MEMORANDUM

DATE:	May 25, 2022	RWDI REFERENCE #: 1904405
TO:	Simon Joseph	Email: Simon.Joseph@jhg.com.au
FROM:	Ryan Danks	Email: ryan.danks@rwdi.com
	Michael Pieterse	michael.pieterse@rwdi.com
RE:	Overshadowing – Southern Precinct Update Waterloo Metro Quarter

Sheet title
General Arrangement Plan
Roof Plan

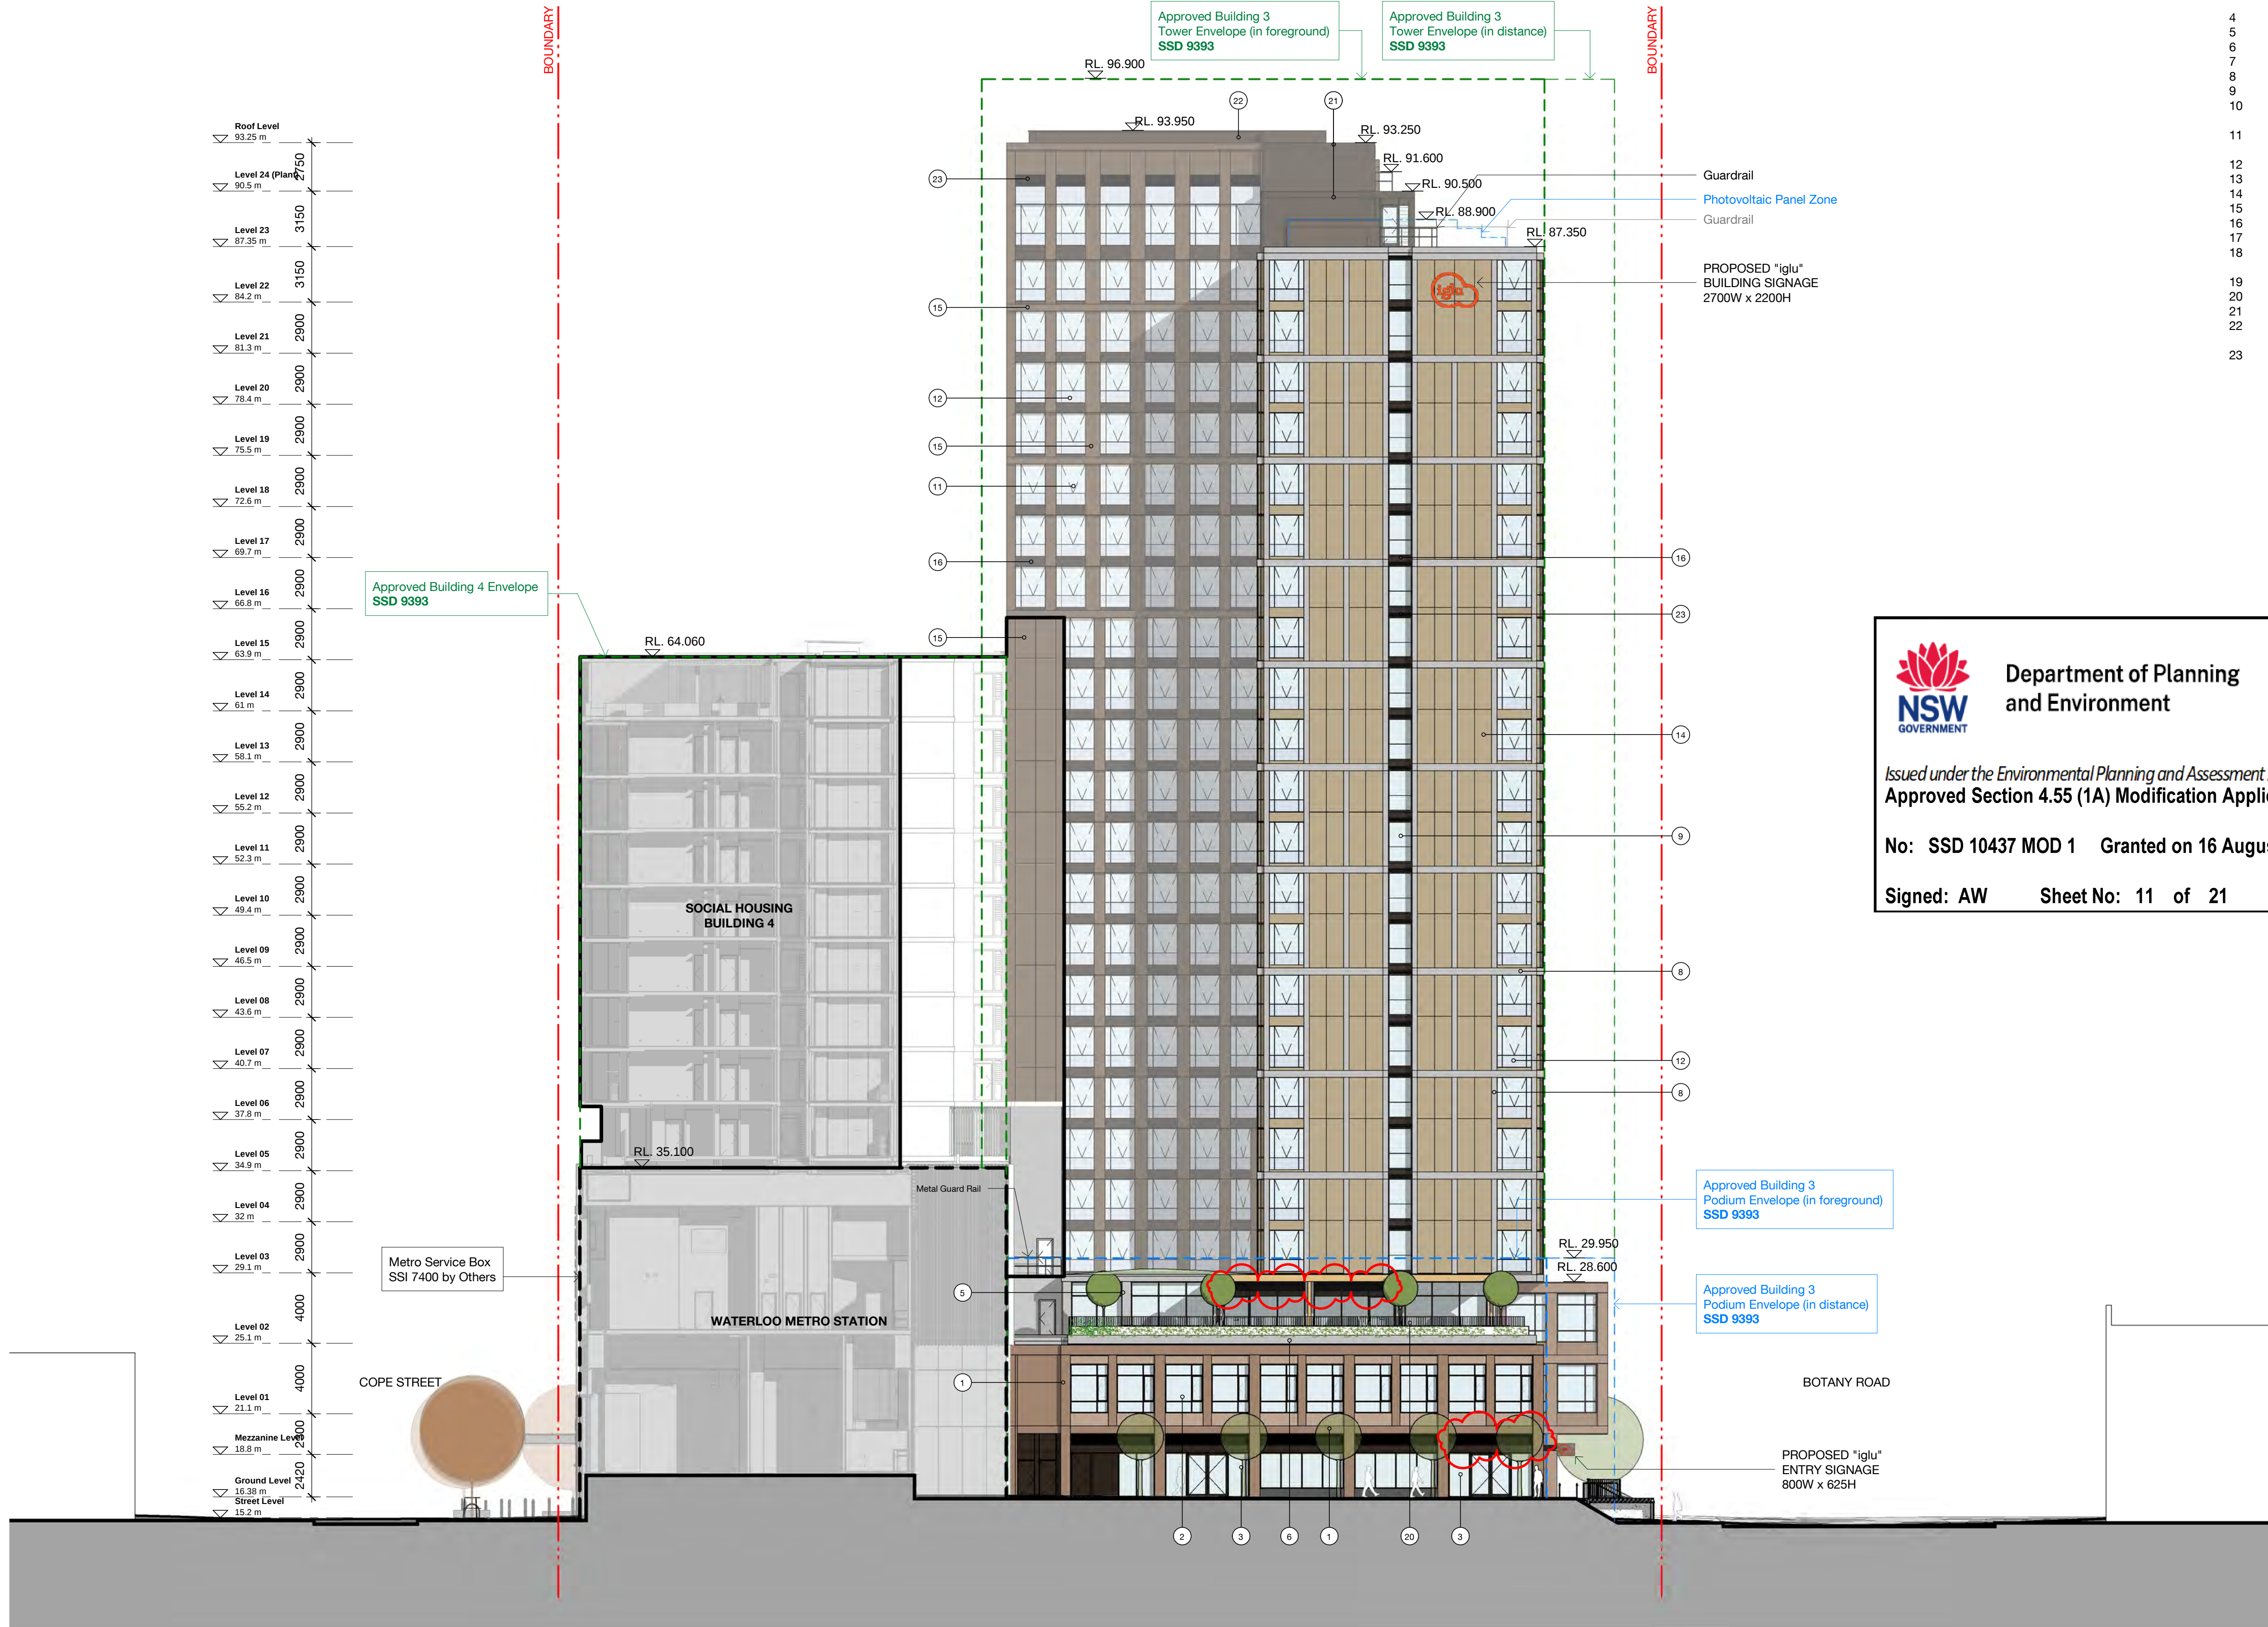
RWDI understands changes have been proposed to the height of plant areas located on the roof of Waterloo Metro Quarter (WMQ) Building 3. We have been requested to assess whether the current design inclusive of proposed changes is compliant with the SSDA submission. The criteria for the site were previously set out in Appendix LL Overshadowing Analysis submitted as part of the EIS for SSDA 10437.

With respect to criterion 1, the modifications at the roof top of Building 3 do not penetrate the 10 am solar plane, thus the development remains in compliance with this portion of the regulations.

With respect to criterion 2, the shadowed park area was recomputed for the 9 AM (i.e., the most onerous) test time using the same methodology as previous RWDI analyses. The analysis found that there is no increase in the overshadowing impact due to the changes in the roof layout since submission of Appendix LL of the EIS for SSDA 10437, and criterion 2 is still being achieved.

Therefore, the proposed development is predicted to be compliant with both criteria for Alexandria Park and consistent with the previous analysis.
